**SDRP #3 Response**

State Significant Development SSD-17424905  
 Pymble Ladies College – Grey House Precinct  
 20 Avon Road, Pymble (Lot 1 DP 69541)

**Table 1 RESPONSE TO SDRP Meeting #3 – 16 March 2022**

SHADOW DIAGRAMS -
SHEET 4

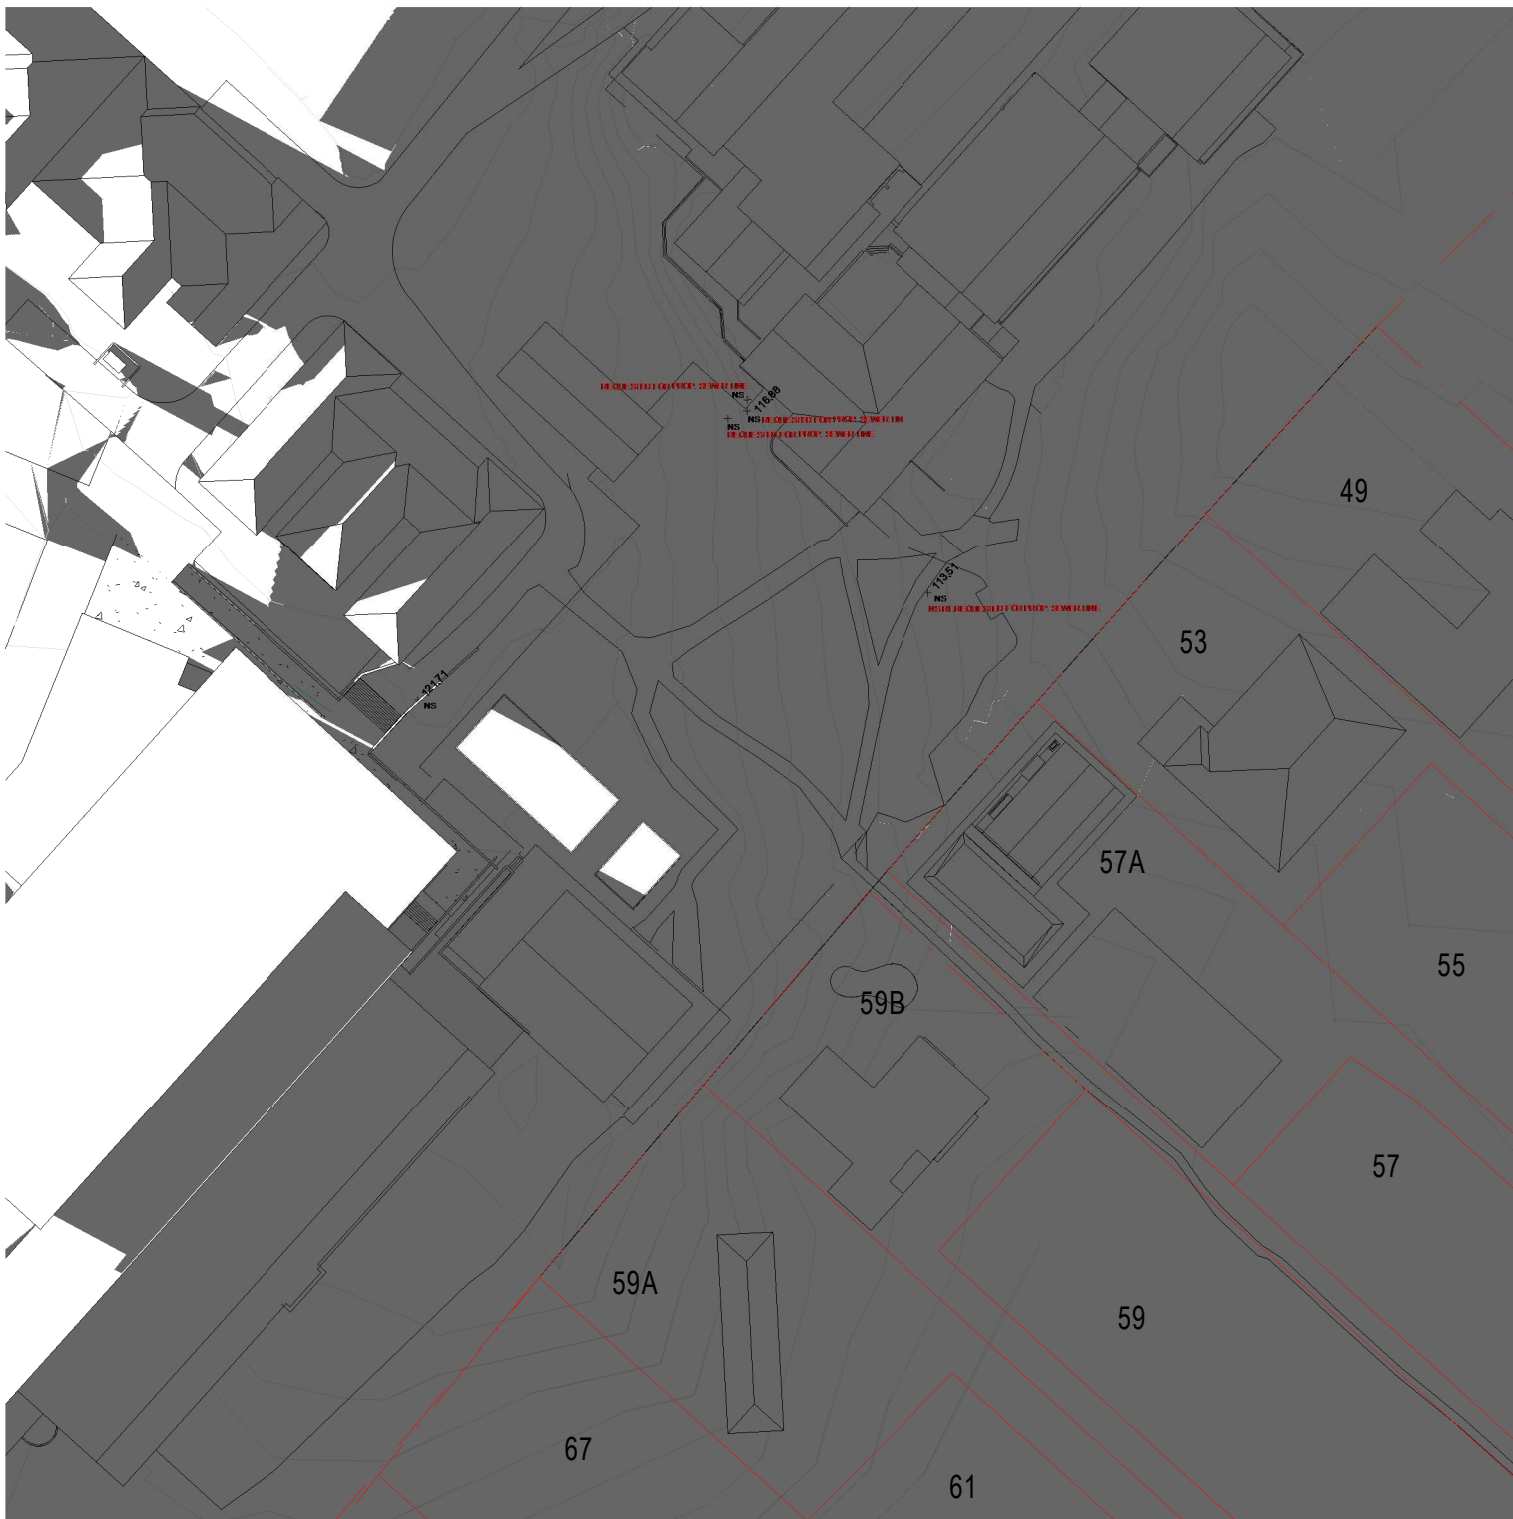
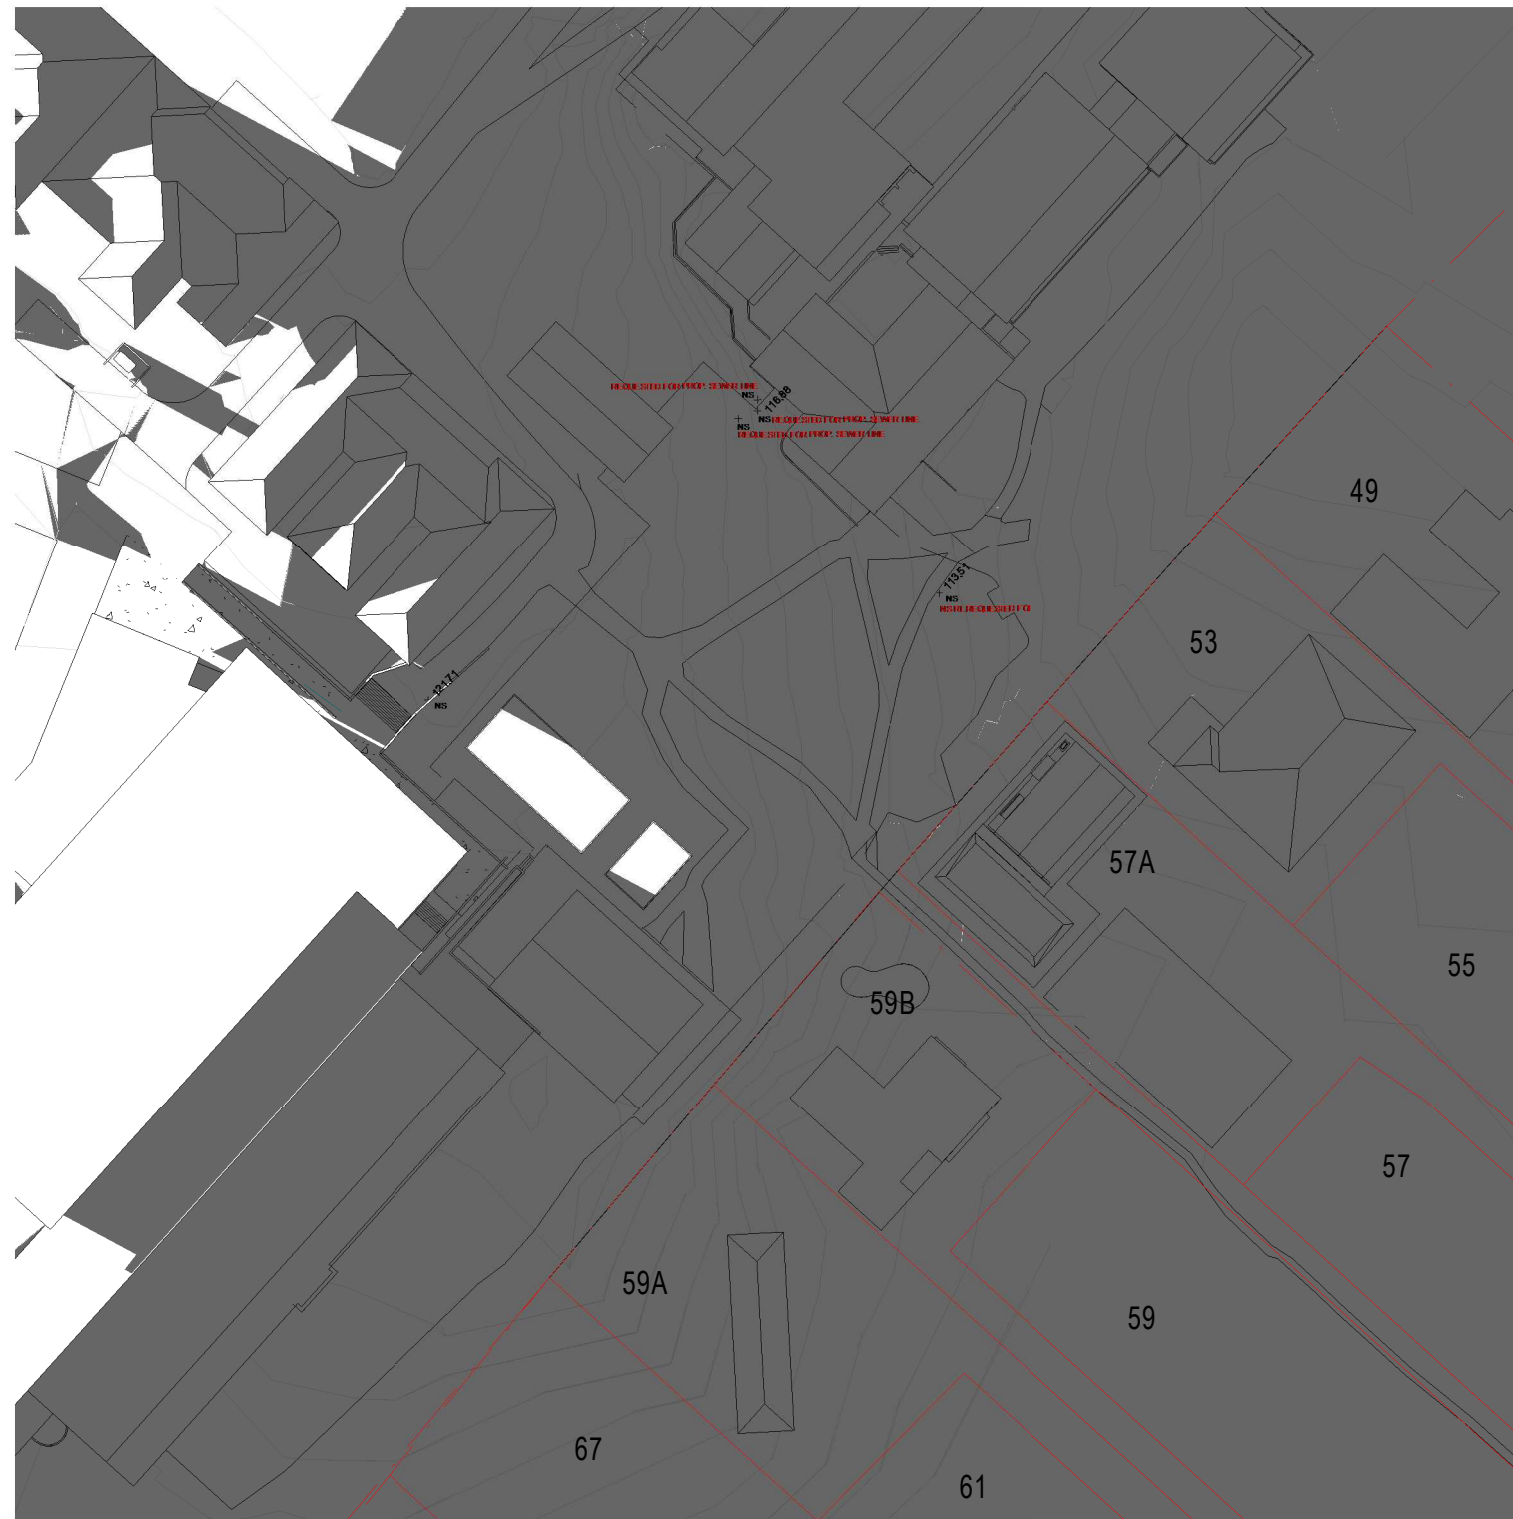
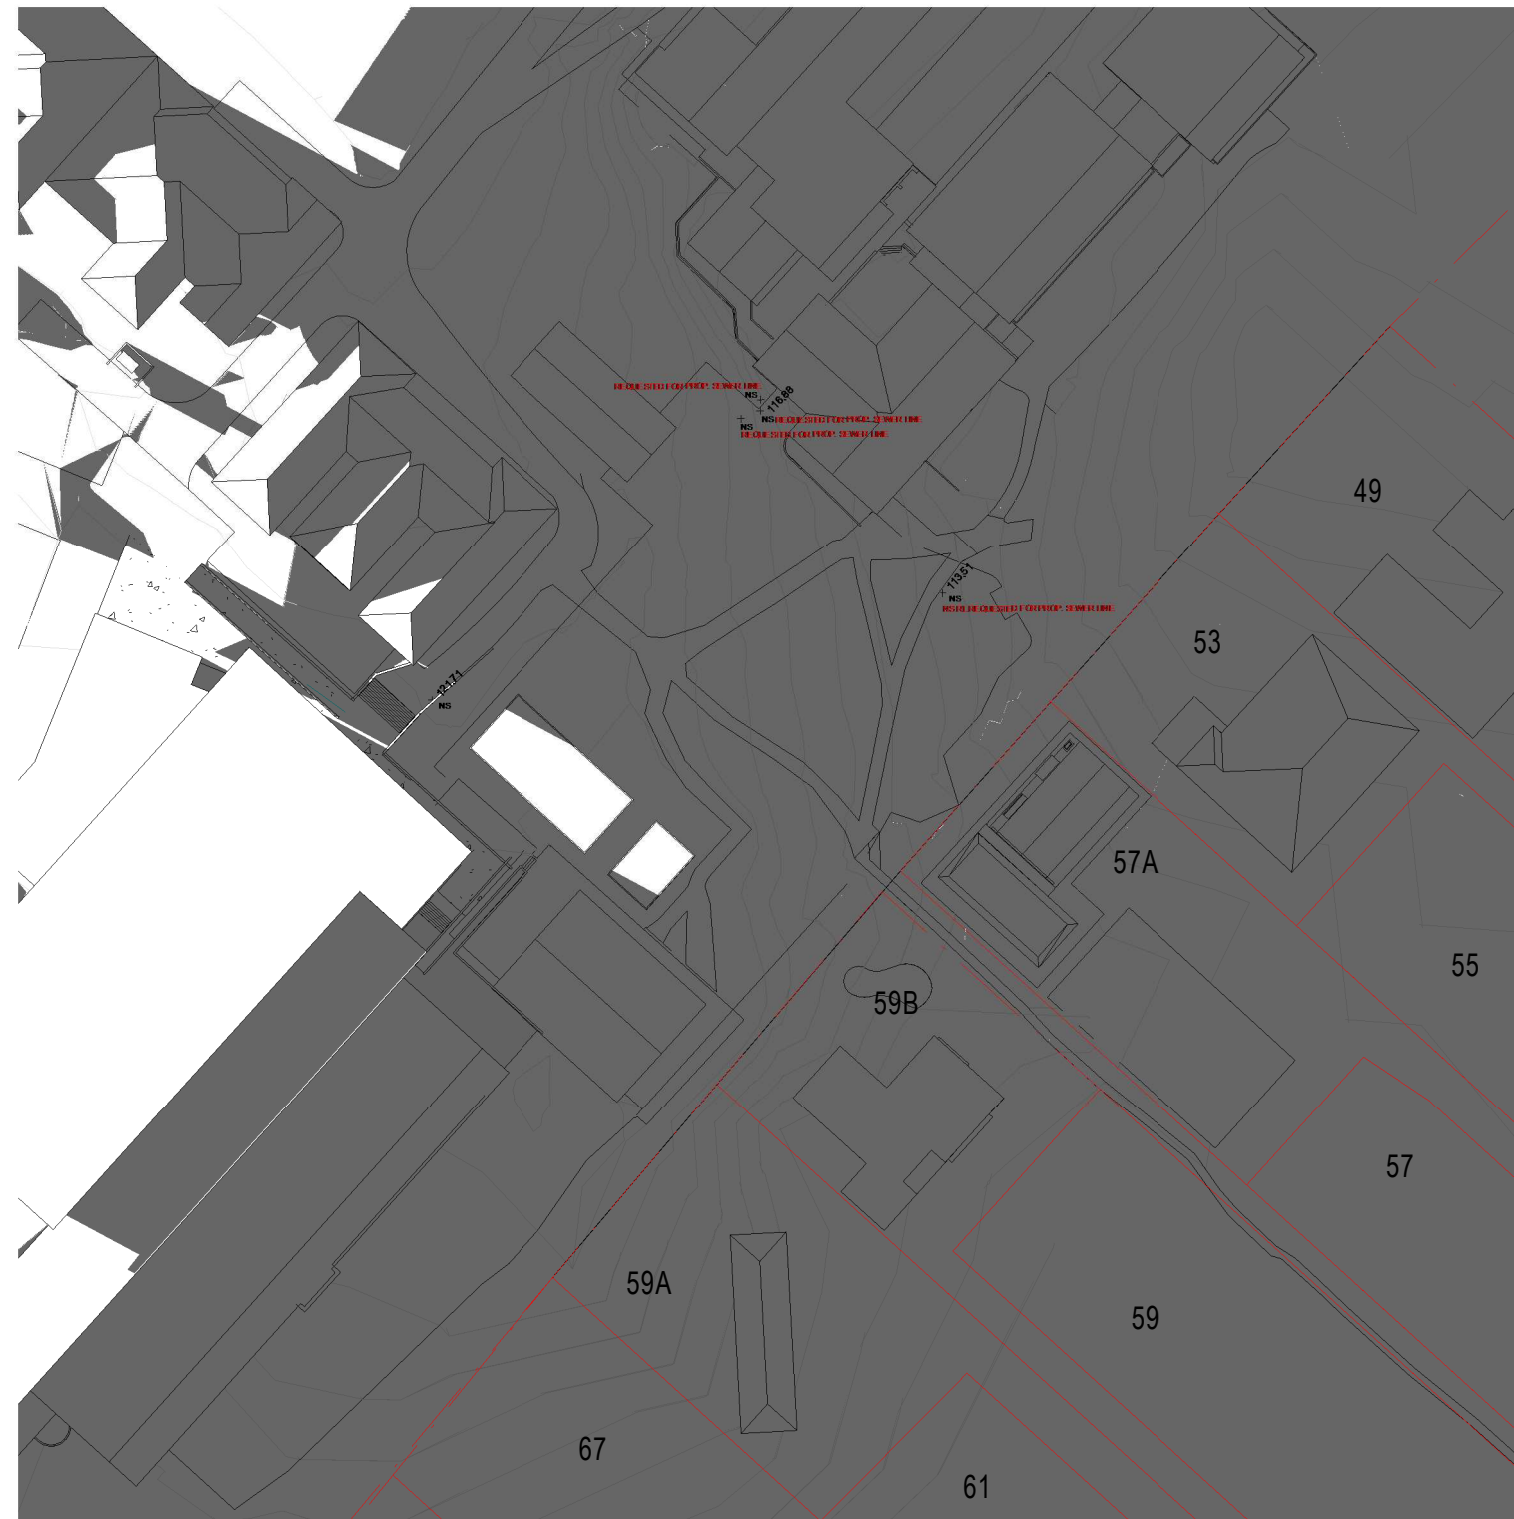
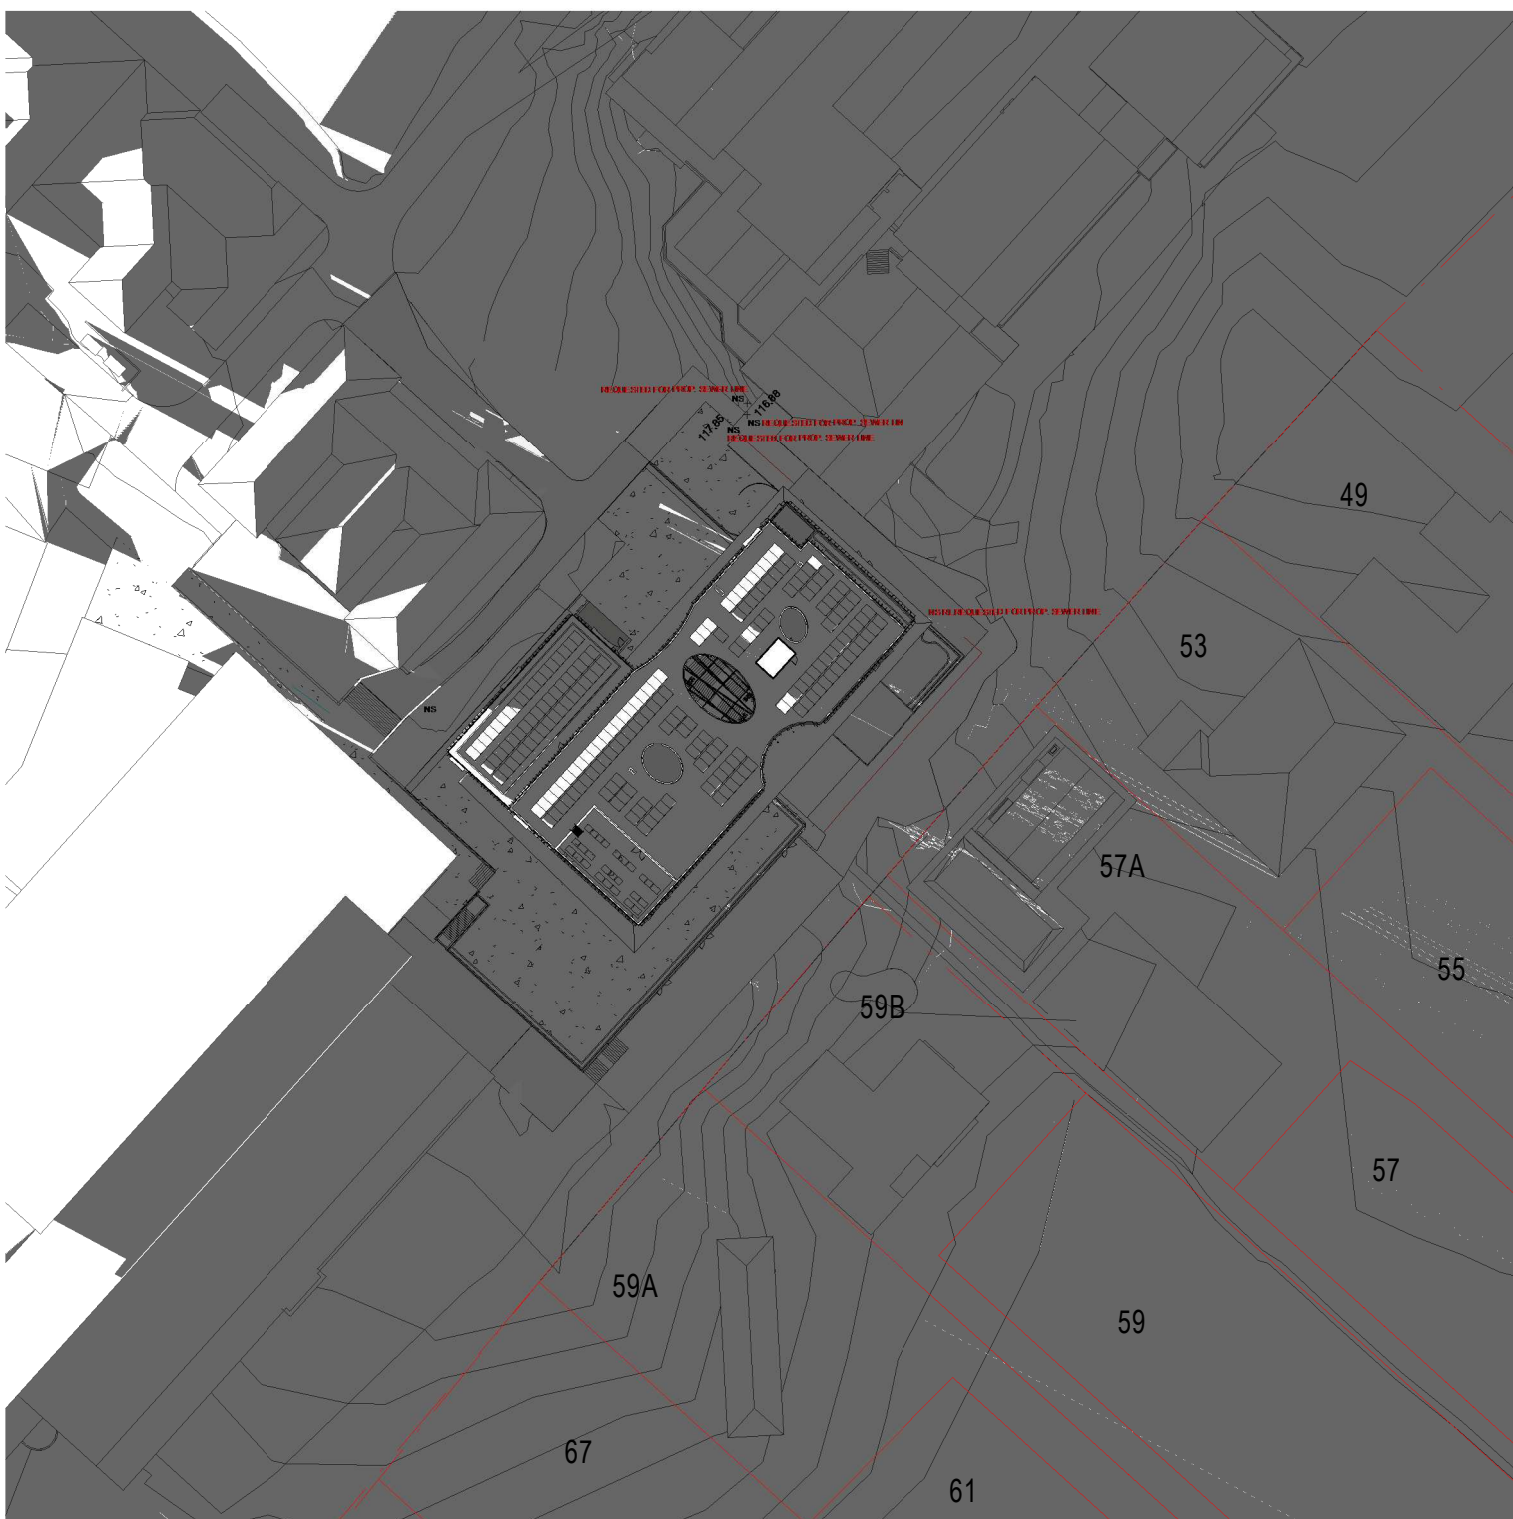
11. Clarify the impact of the proposal on the solar access of the adjoining properties, as this has not been clearly demonstrated. Provide existing and proposed diagrams identifying the quantum of solar access to the living area glazing and the principal private open space of affected properties to demonstrate if a reasonable level of solar access will be maintained for the adjoining properties.	Updated solar diagrams have been included in the Architectural Plans ( <b>Attachment A</b> ) and the Design Report Addendum ( <b>Attachment B</b> ). These clearly demonstrate that there is ample and reasonable solar access to both adjoining residential houses to the south. The private open spaces and internal living spaces of these two dwellings receive at least 3 hours of solar access between 9am-3pm in mid winter with the majority of private open space for each of the dwellings receiving 4 or more hours of solar access. It is considered that there is a reasonable level of solar access maintained to both dwellings.
